Description: Change of use from private dwelling to 3 self-contained apartments. Two storey side extension and rear extensions. New dropped kerb to side/rear, new parking area and solar panels to roof.

Site Address: 2 Houghton Road, Thurnscoe, Rotherham, S63 0JT

This application seeks permission for a change of use from a private dwelling to 3 self-contained apartments, a two-storey side extension and rear extensions. In addition to a new dropped kerb to side/rear, new parking area and solar panels to roof.

SCALE: 1:50 | DATE: 31/08/2022 | DWG No: 026-04 | REV: B

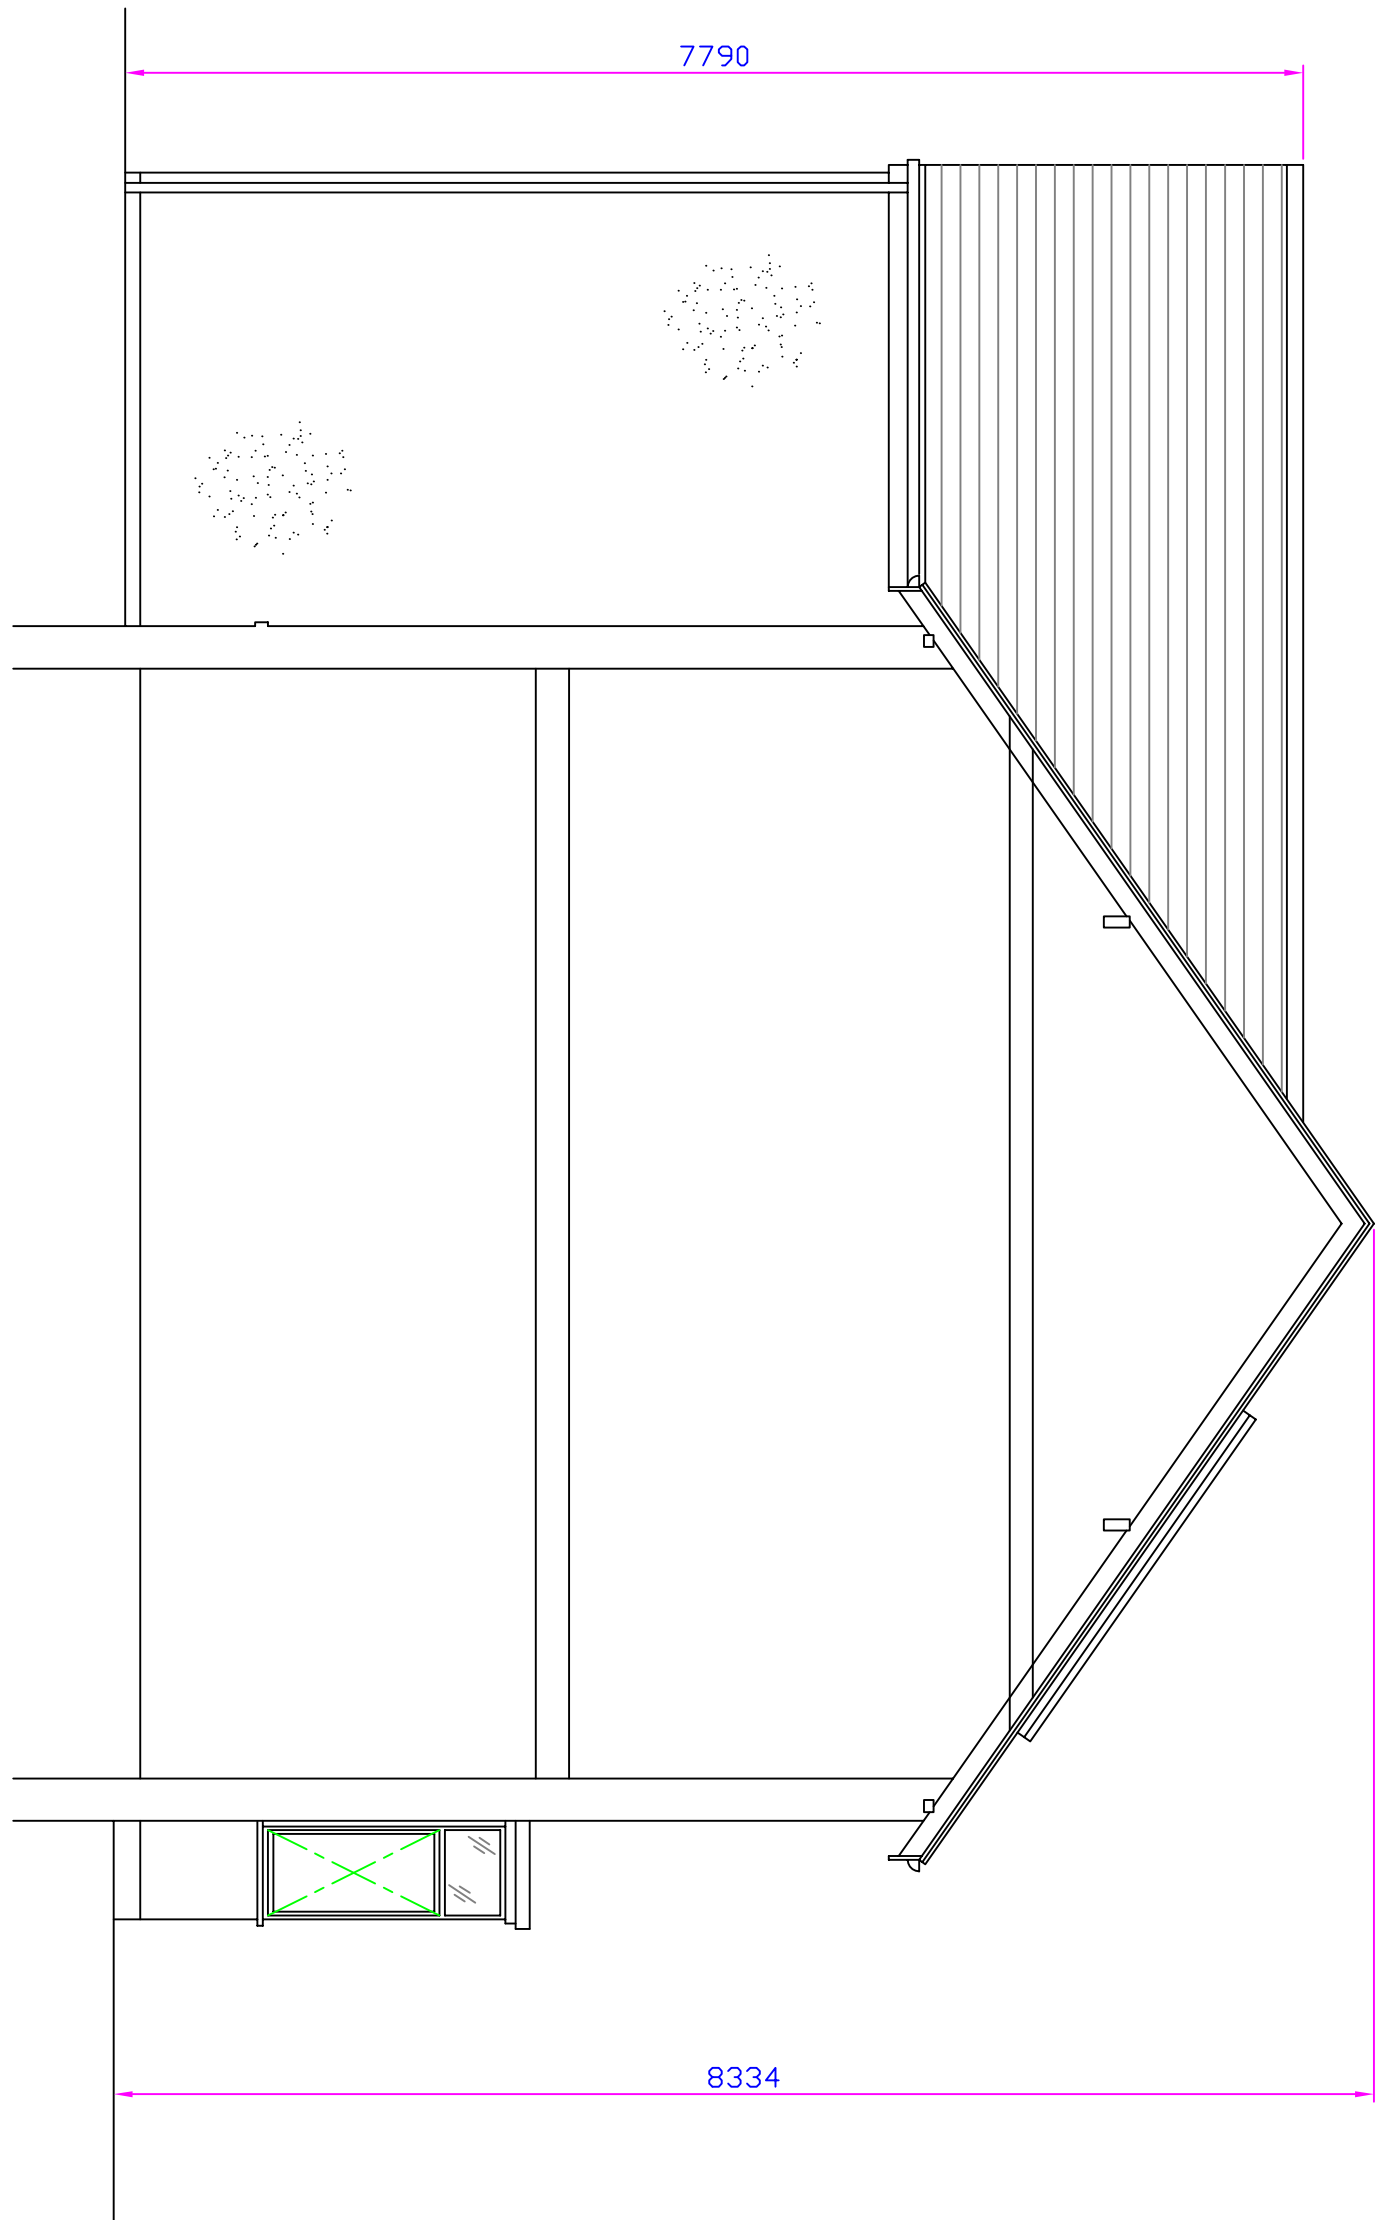
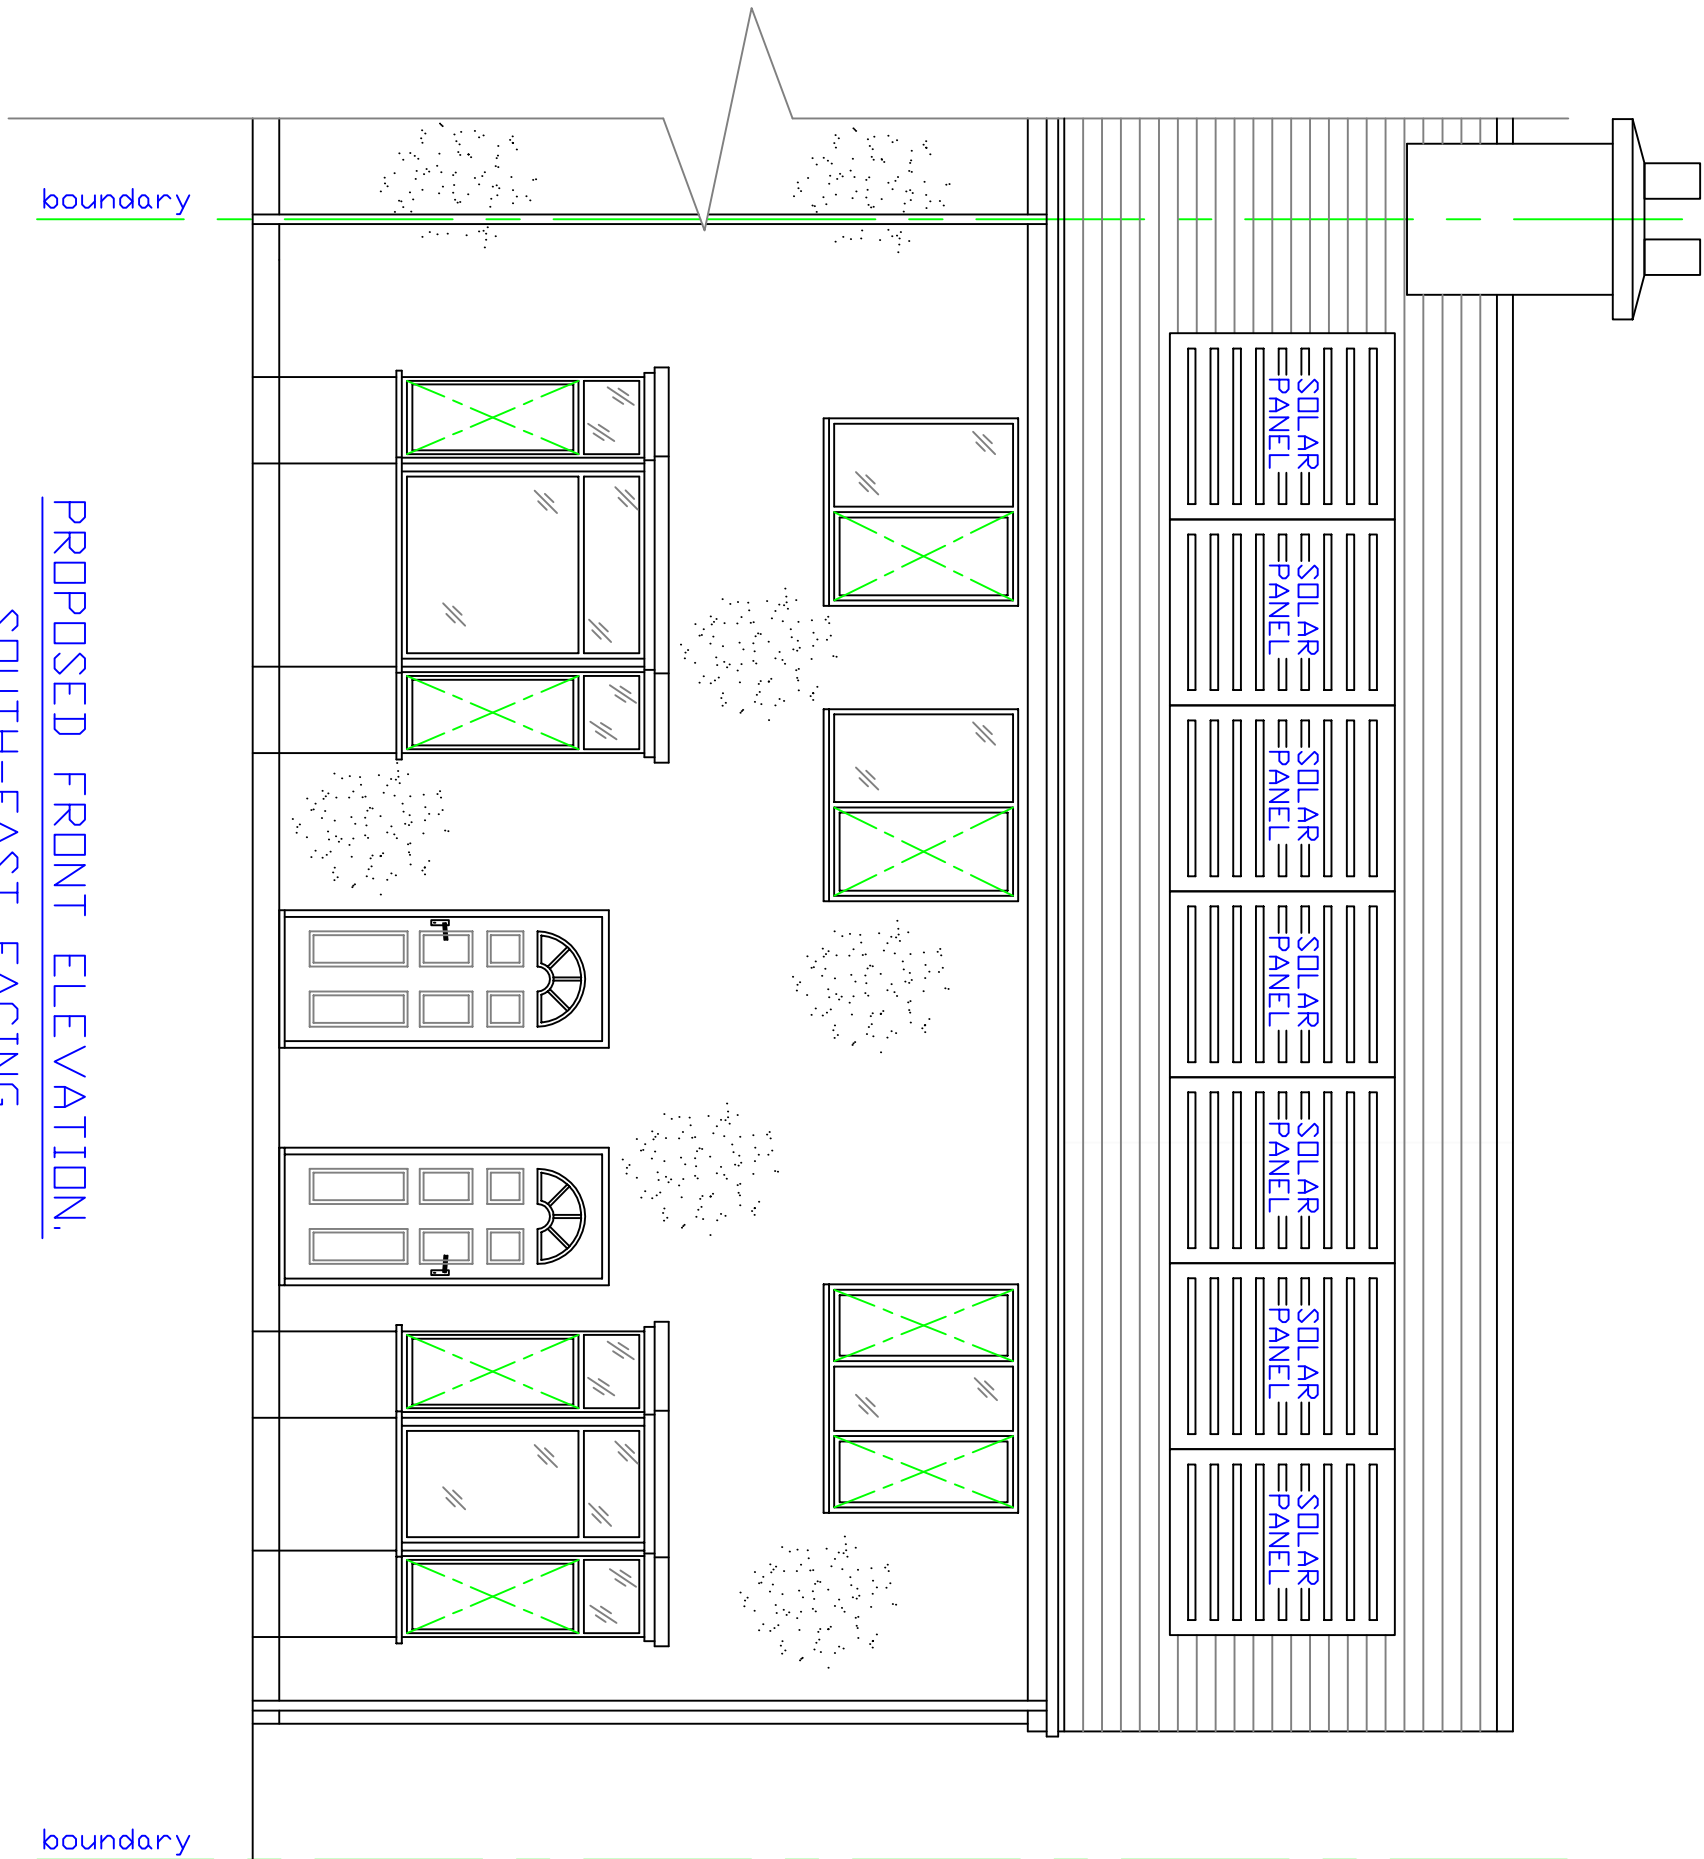
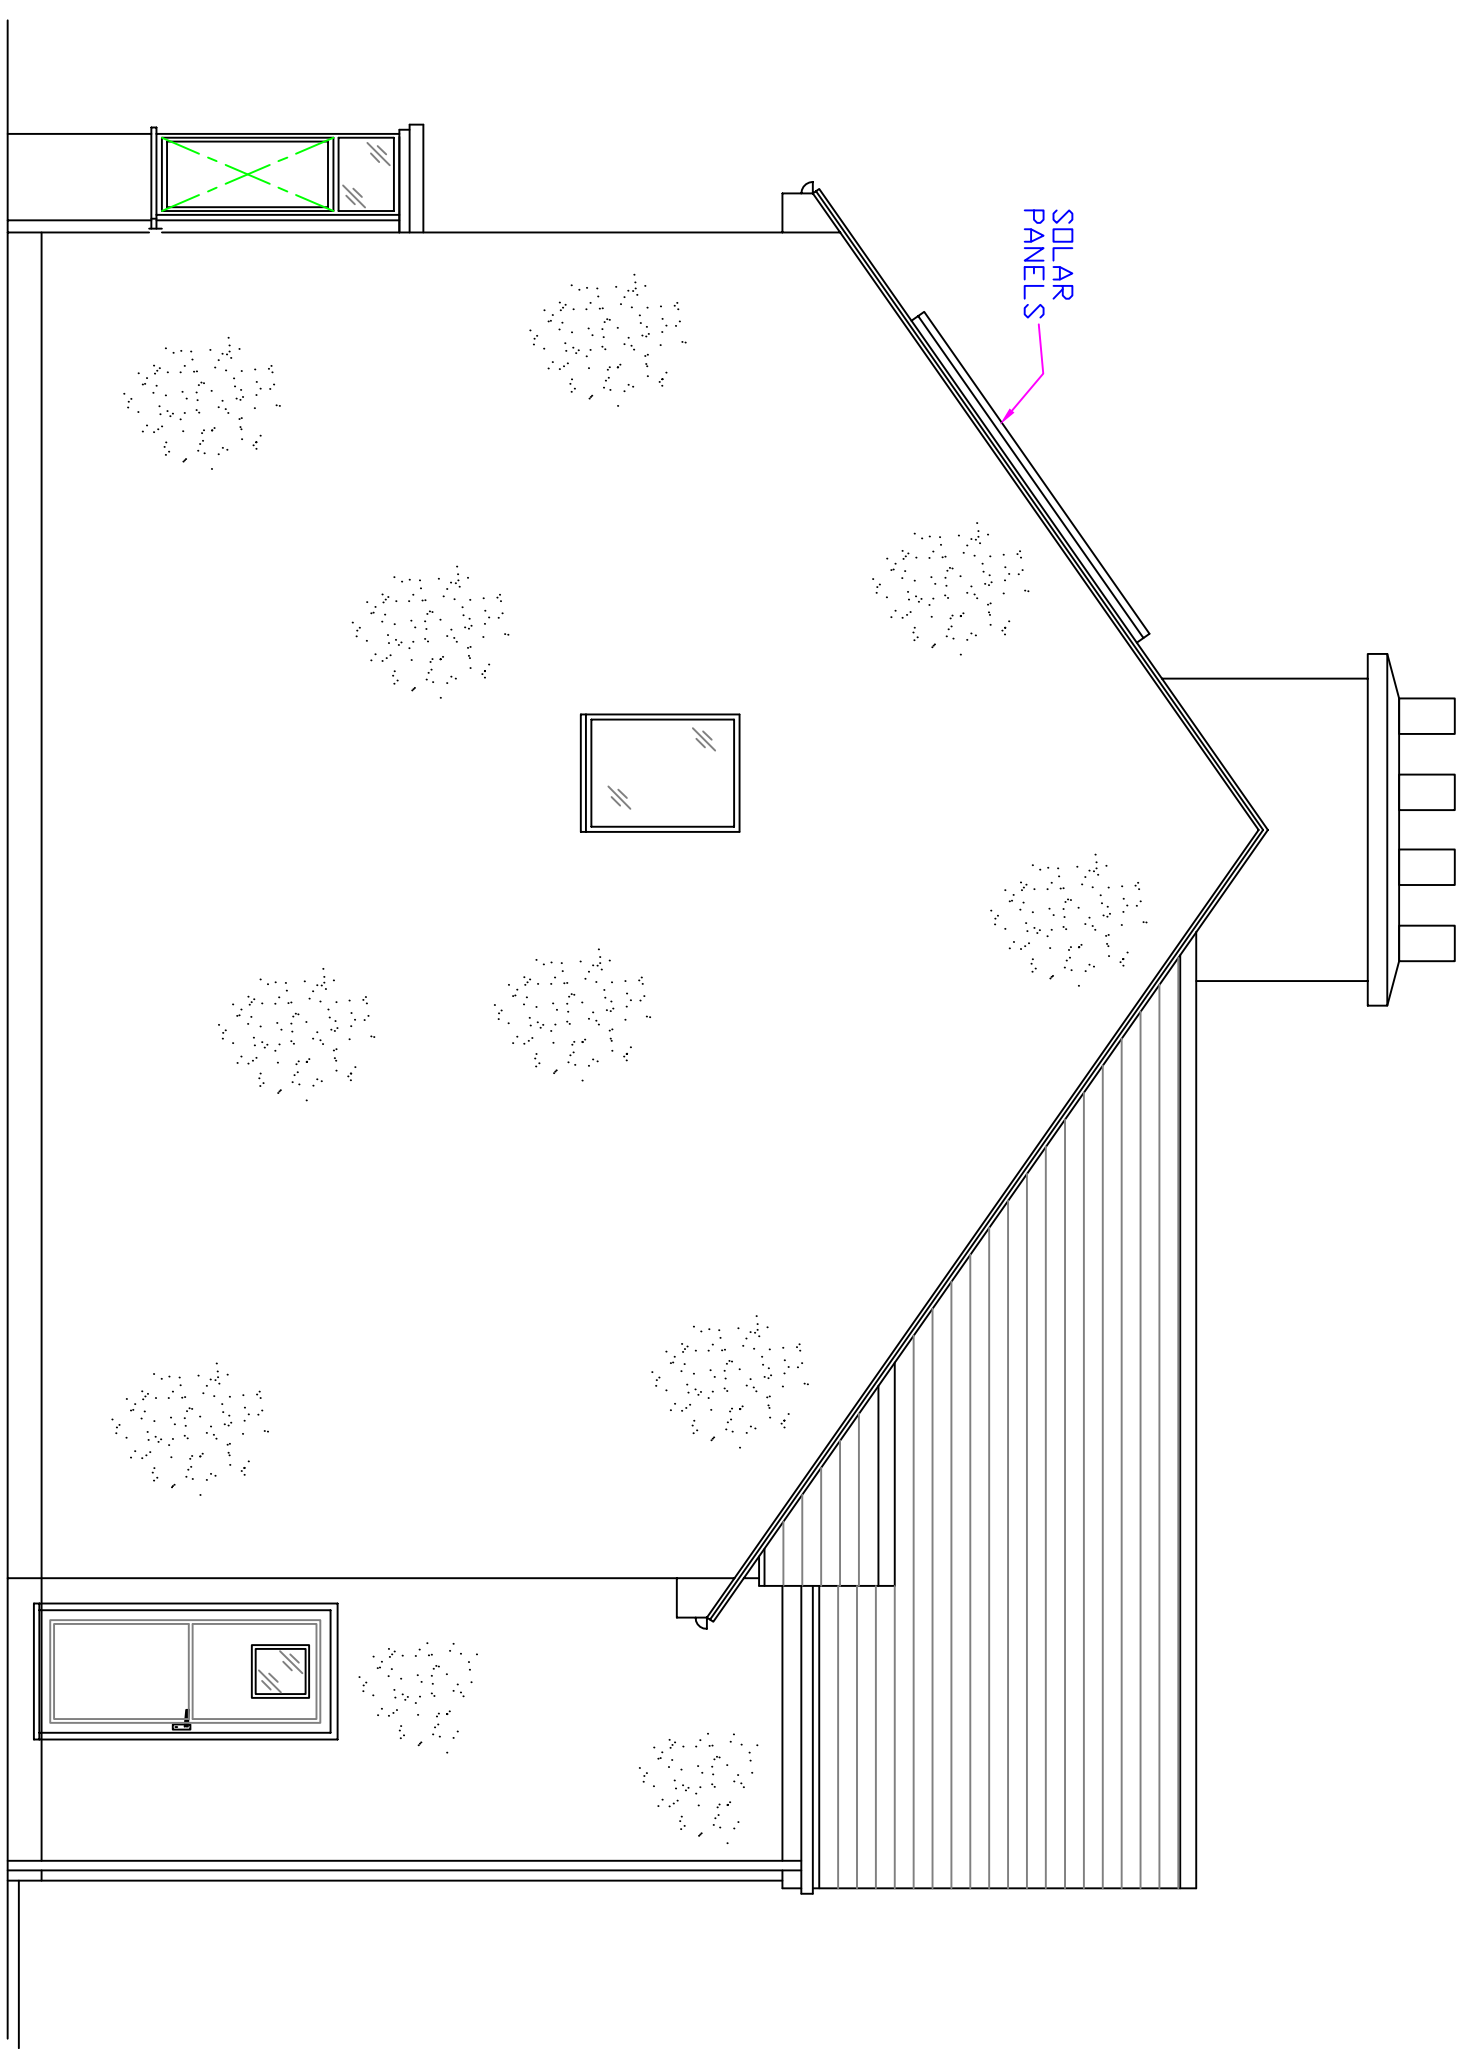
In this case, the two-storey side extension has a dual pitch roof alike the existing dwelling, however the extension fails to provide a setback from the front wall of the dwelling, from the side boundary or from the rear (which is necessary in the case of a corner plot). In this particular case, there is no adjacent dwelling to the east and as such a set in from the side boundary would not be a detriment as no terracing effect would be created to this elevation.

The dwelling is located on a corner plot and as such, the sideways projection of the extension should not exceed more than half the width of the gap between the side elevation of the original dwelling and the side boundary. The distance between the side elevation and boundary is approximately 4.9m and as such the extension would be permitted to be 2.45m in width. The extension measures 4.32m and as such does not conform to this standard.

In this case, the extension does not appear subservient and instead appears to dominate the dwelling, providing no setbacks in any direction. Therefore, the extension would not only be detrimental to the subject dwelling but to the other semi within the pair of dwellings and surrounding street scene due to the dwelling's location on the corner plot which exacerbates the extension.

The rear extension would project 3m from the rear wall of the dwelling and would have a gable roof alike the existing roof of the dwelling. The extension would conform with the SPD in terms of its depth, however it is considered that the rear extension would appear out of character in the row of dwellings and in the pair of semis and additionally would be highly visible from the John Street/Houghton Road junction, exacerbated by the dwellings location on the corner plot.

The proposed extension is to intersect the 45-degree quadrant by approximately 1.17 meters and it is considered that the proximity of the extension to the party boundary and the substantial expanse of brick work will limit levels of outlook and have an overbearing impact on the adjoining property to the detriment of residential amenity which would conflict with Local Plan Policy D1.
